Historic England

**THE CROSS, WYKE LANE/CROSS STREET, OAKENSHAW
Application Nos 2025/65/93234/E & 2025/48/93235/E**

Thank you for your letters of 10 December 2025 regarding the above applications for listed building consent and planning permission. On the basis of the information available to date, we offer the following advice to assist your authority in determining the applications.

Historical Disc

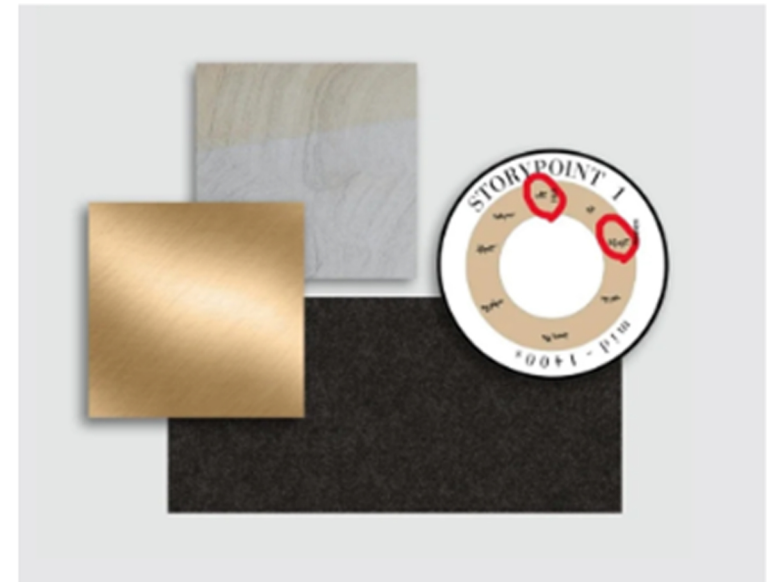
However, the proposal includes some mitigation including the story point style demarcation of the original position of the cross in addition to interpretation boards. These interpretation boards should look to maximise public benefits as much as possible by being accessible and including digital resources. Innovative approaches to interpretation should be explored as part of the reinstatement project. Other benefits including the a landscaping scheme would encourage people to interact with the
